Your Ref: OWPC19703
Our Ref: BE/74/18/PL 20-06-2018
Please ask for:
Mr S Davis

Erection of 1 No. attached dwelling
1 Finch Gardens Bersted

Thank you for your internet representation made on 20th August 2018 which has been recorded as '**an objection**' with the comments as follows:

CLIENT	PROJECT	TITLE	STATUS	DRAWN BY	REVIEWED BY
KELLY WESSON	1 FINCH GARDENS NORTH BERS TED	ATTACHED DWELLING PROPOSED FL DOR PLANS	PLANNING	SJ	SJ
			DATE	SCALE	
			13.06.2018	1:50@A1	
			DRAWING NUMBER		
			ADC/9/18 – 14

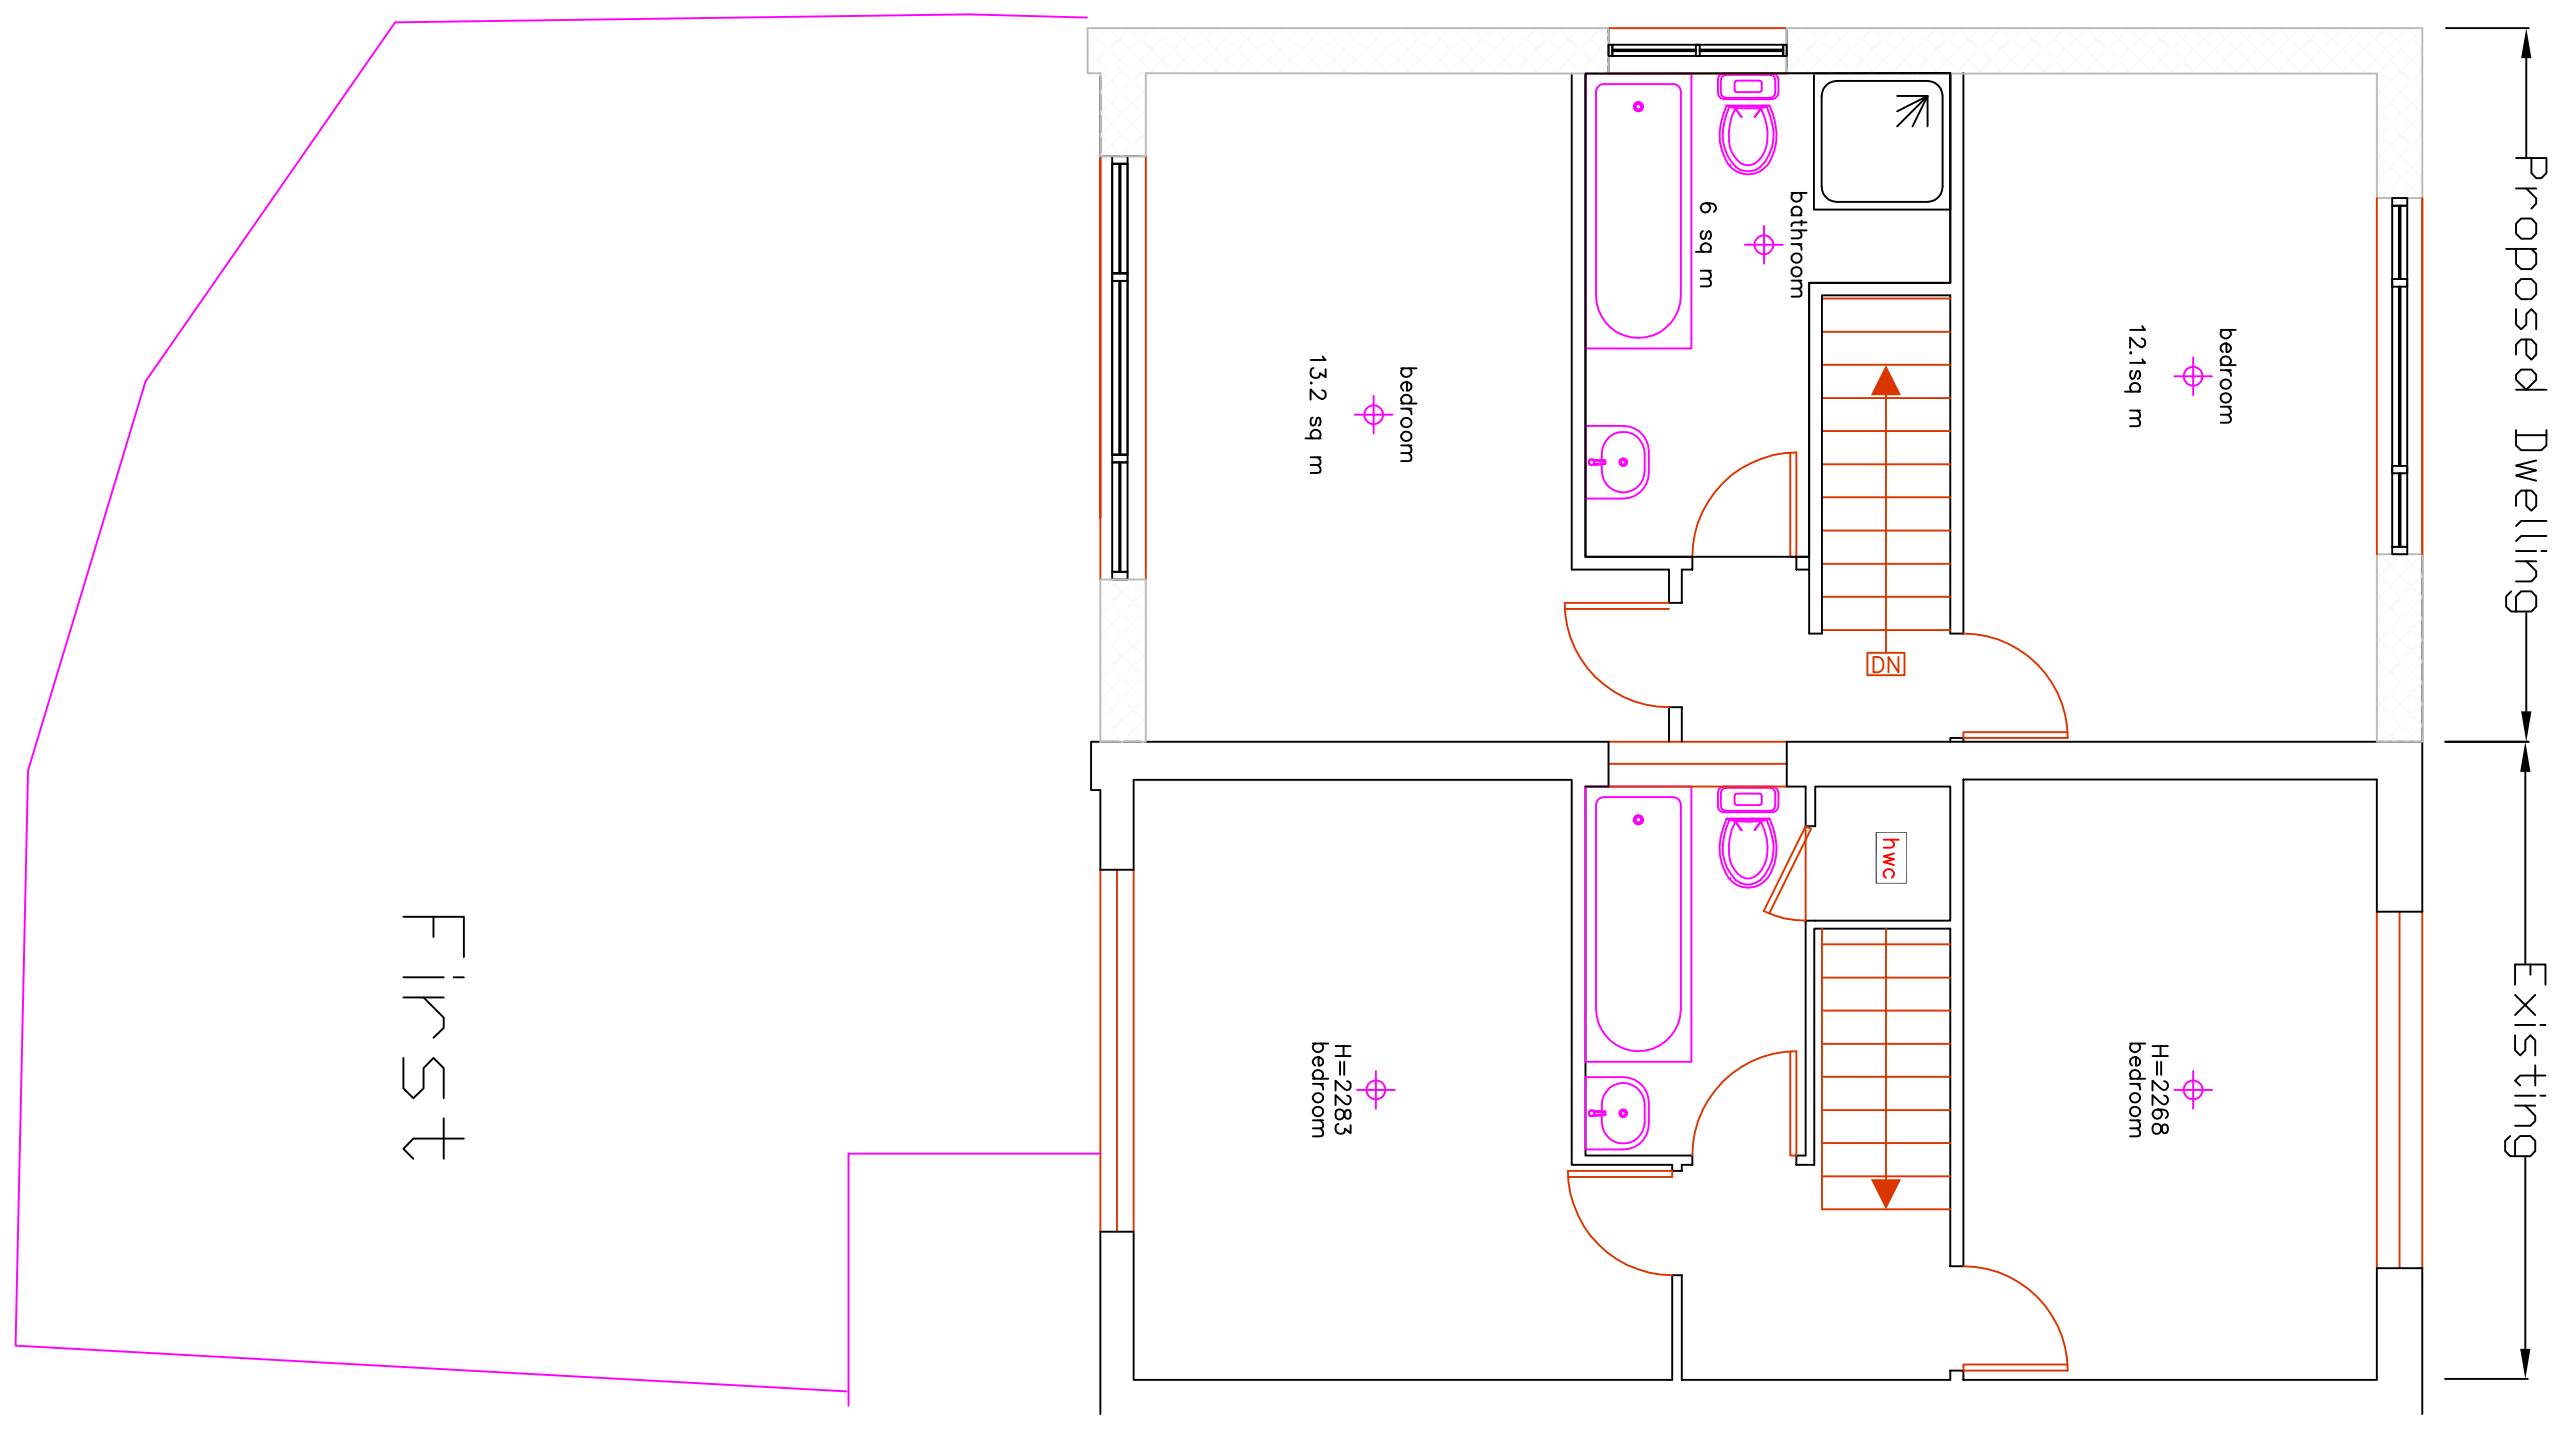
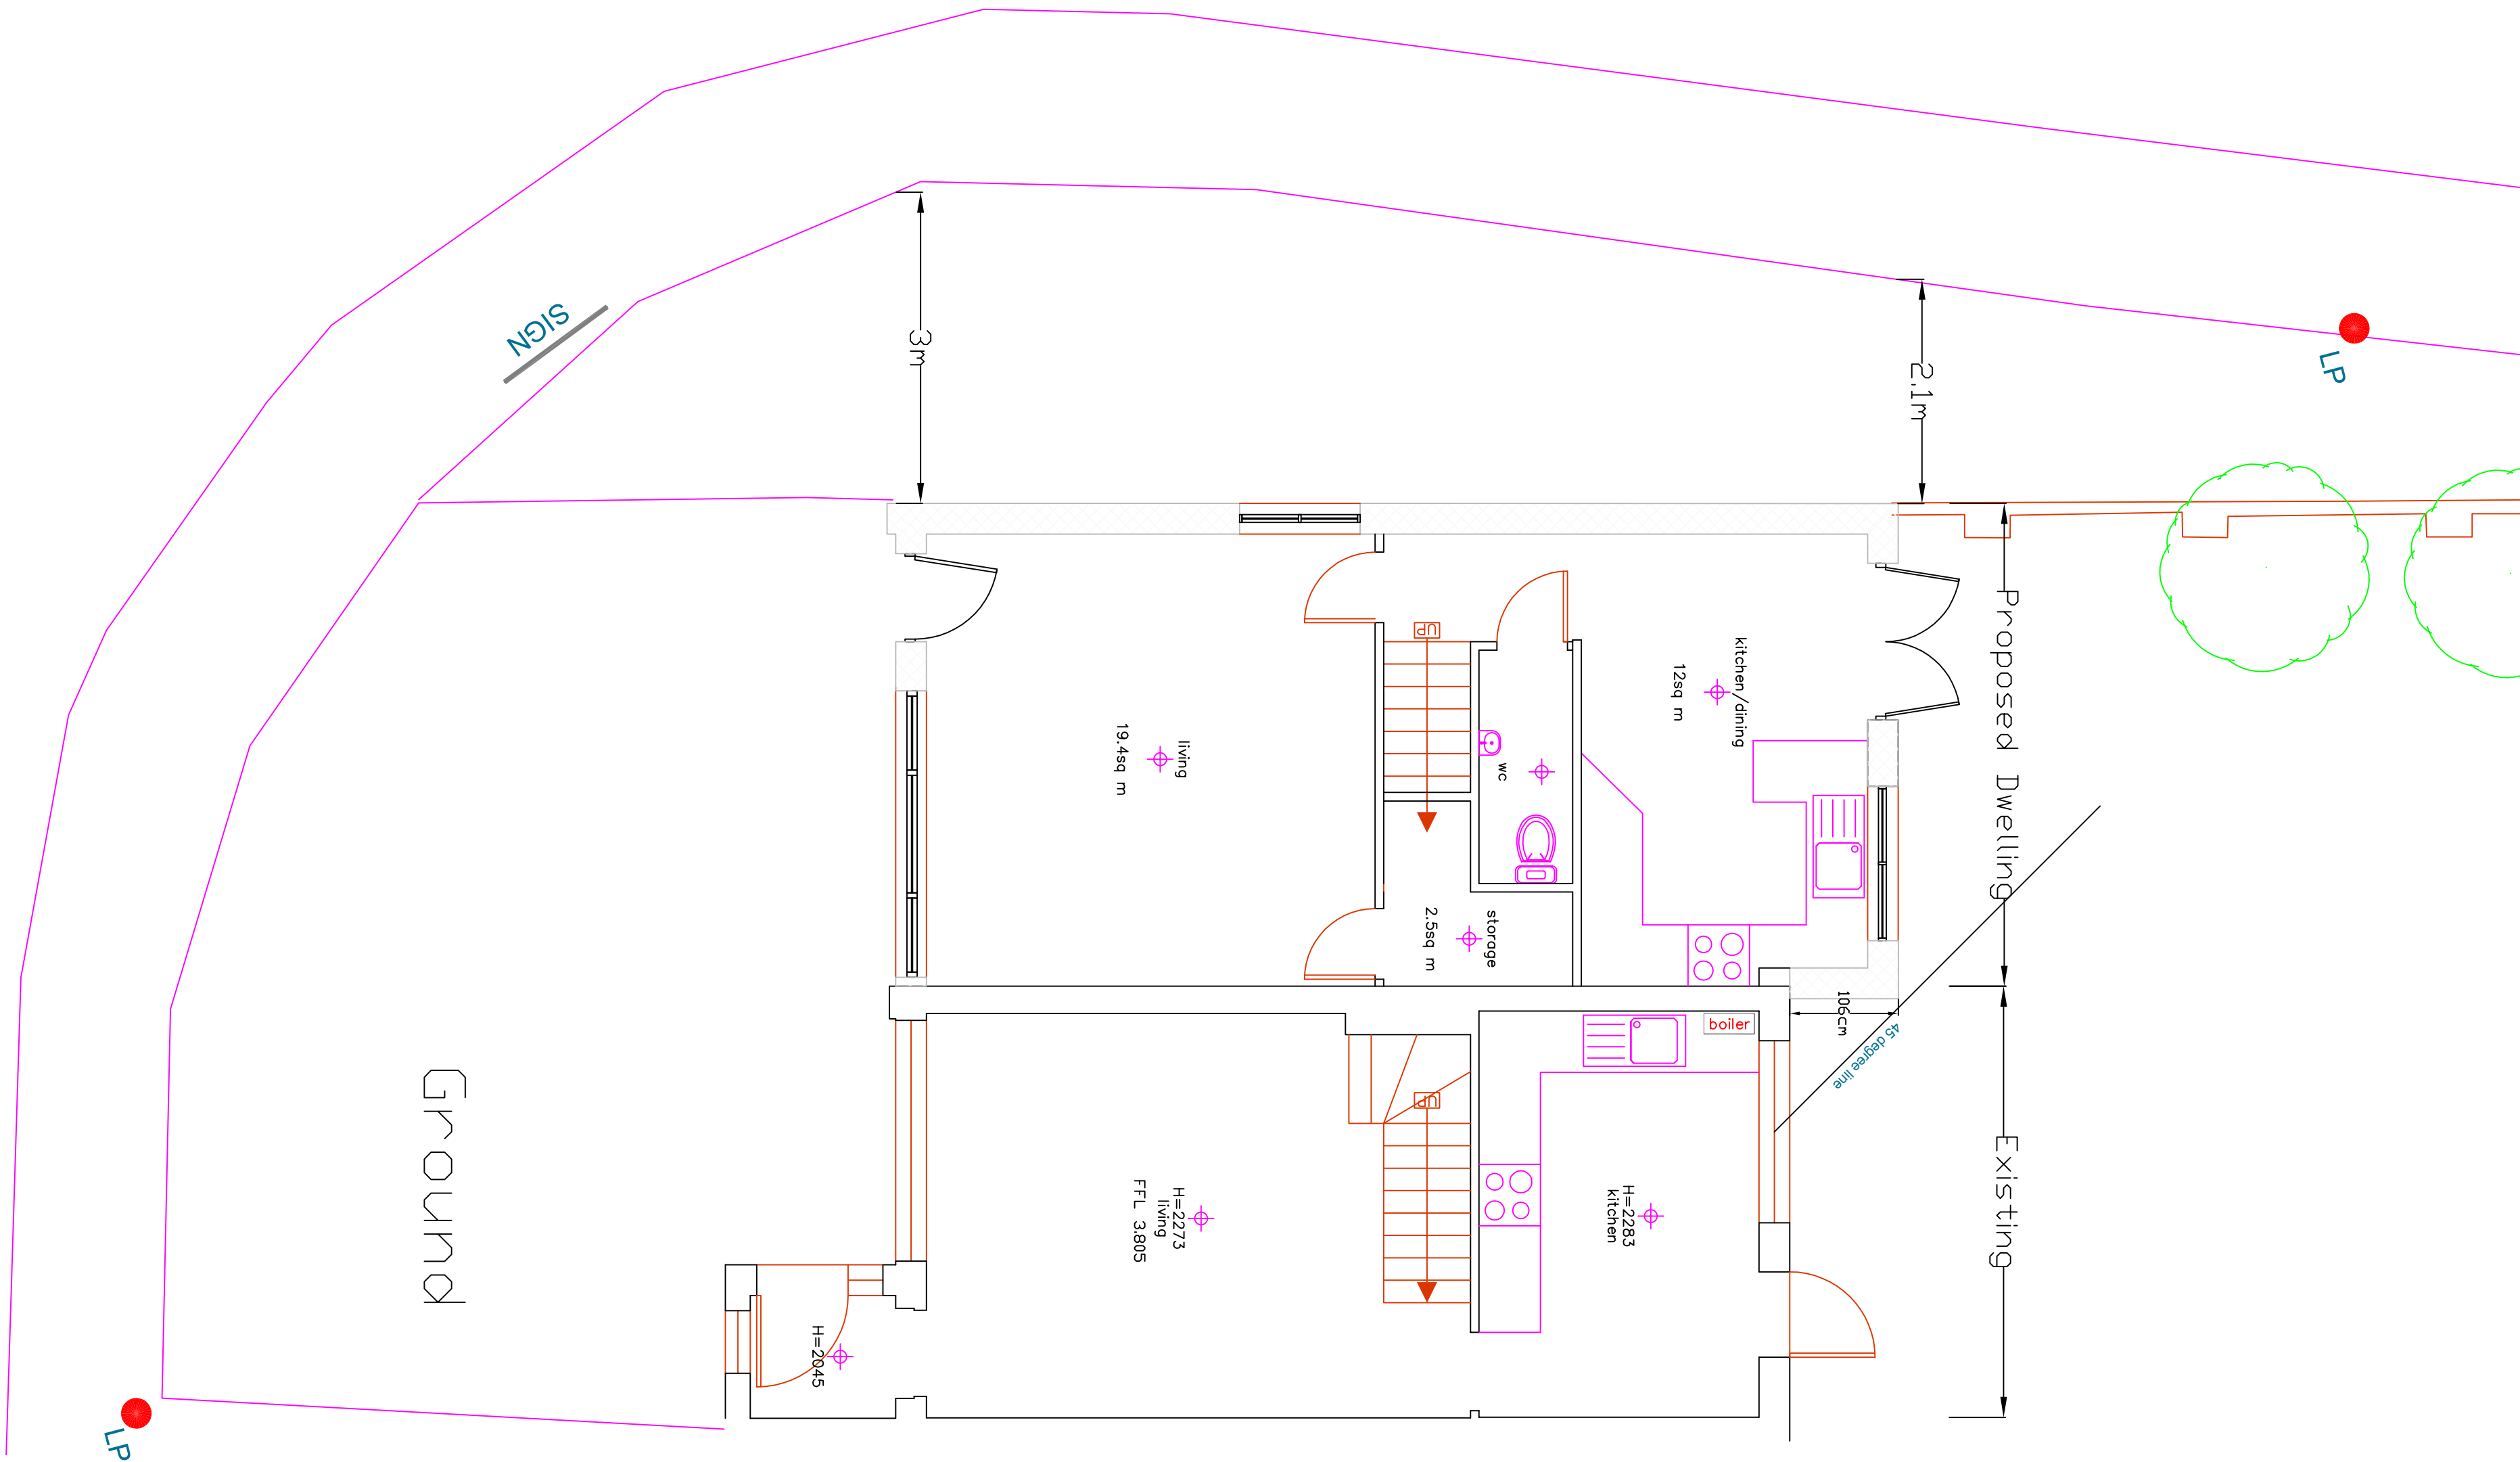
2. Woodlands Road is a busy through road and a bus route. Parking is already an issue in the area and although I note there is provision for parking on the proposed site, I can see it will be inadequate and will result in more vehicles being parked in Woodlands Road as opposed to Finch Gardens, the property's actual address.

CLIENT		PROJECT		TITLE		STATUS		DRAWN BY		REVIEWED BY	
KELLY WESSON		1 FINCH GARDENS NORTH BERTSD		ATTACHED DWELLING PROPOSED ELEVATIONS		PLANNING		SJ		SJ	
						DATE		SCALE		DRAWING NUMBER	
						13.06.2018		1:50@A1		ADC/9/18 - 15

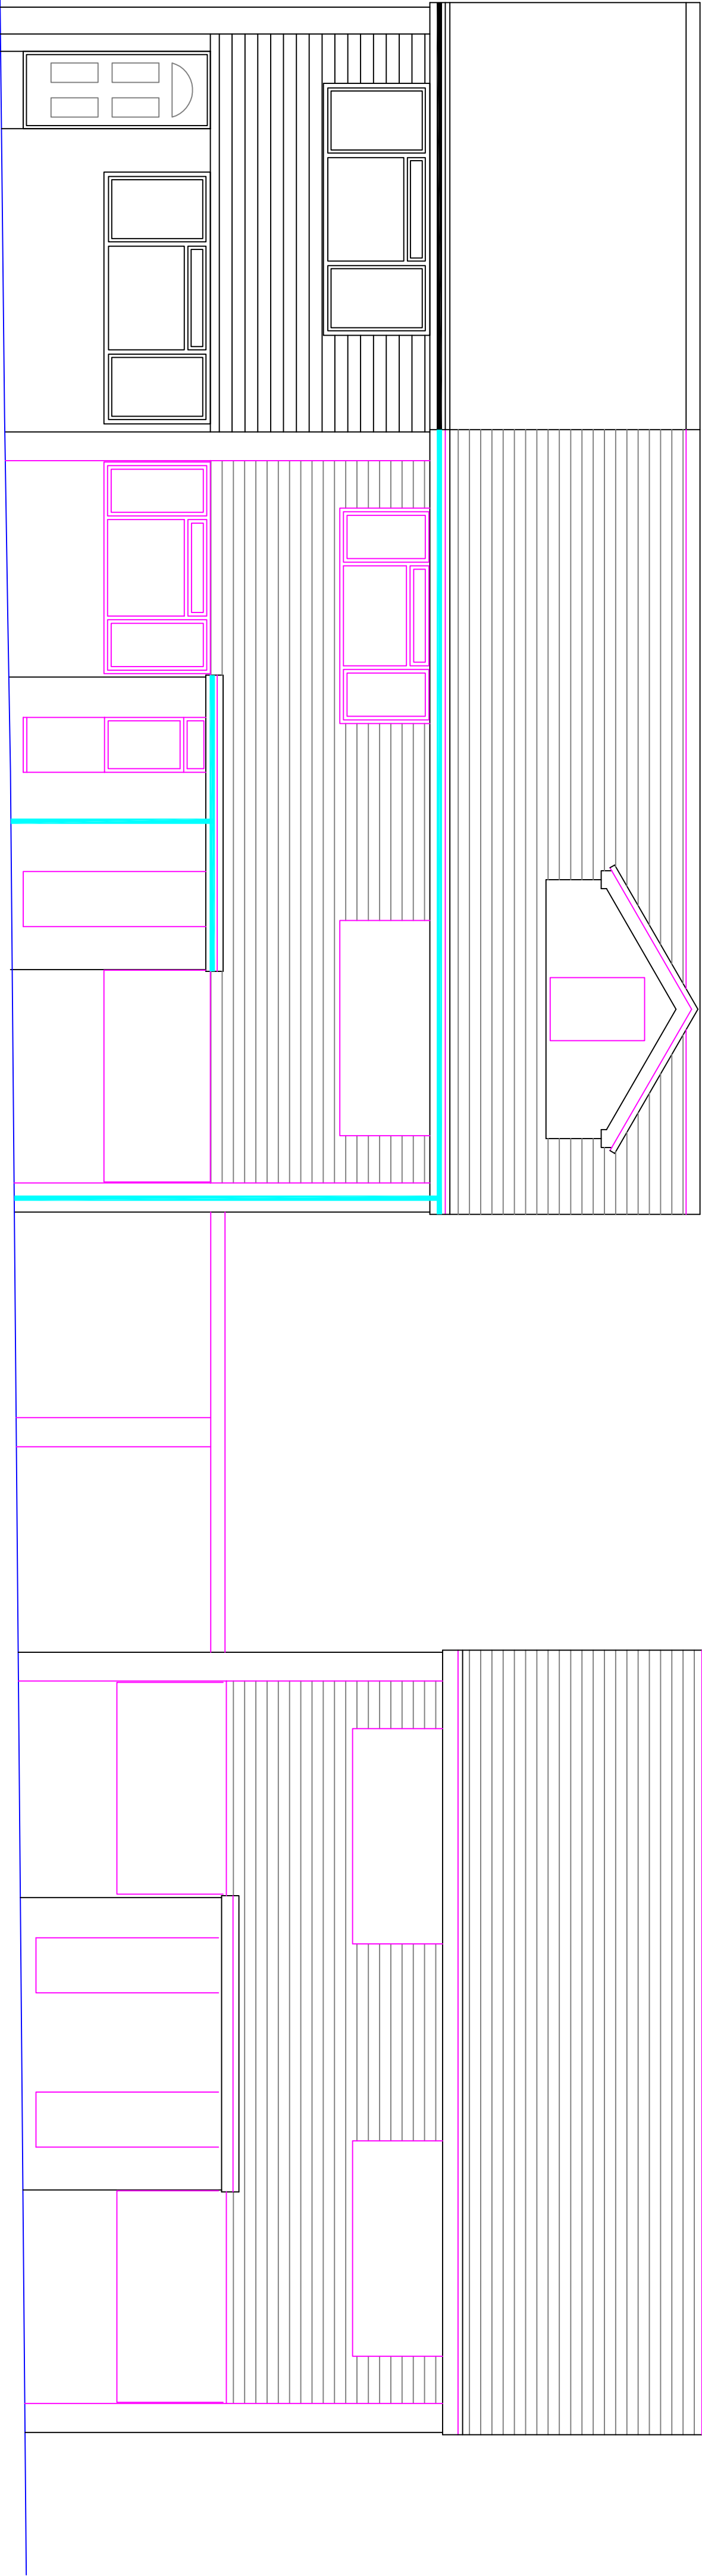
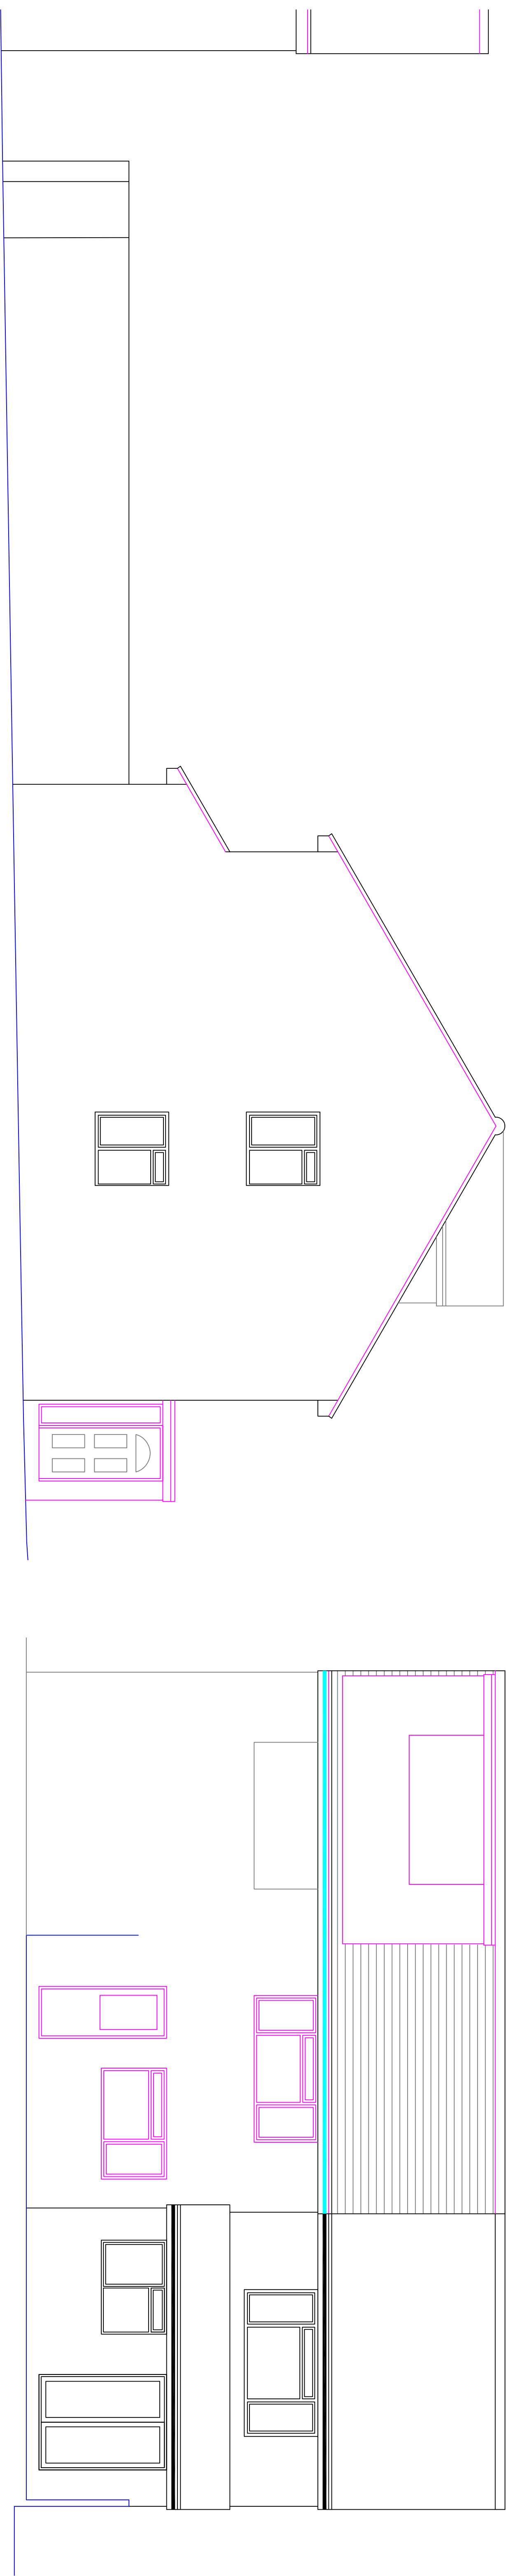
1. I consider that this proposed house would encroach on the current 'open' aspect I enjoy in my home. Although the area is quite built up, the existing properties are located in such a way that the area feels uncrowded. I feel that a building this close to the edge of the road, opposite my property, would be detrimental to the openness of the area, one of the reasons I bought my property in the first place.

3. The existing development in Finch Gardens, as it has been ever since it was built, is of semi-detached houses. To allow the house on the end to add a further house would spoil the whole aspect and be detrimental to the aesthetics of Finch Gardens and Woodlands Road
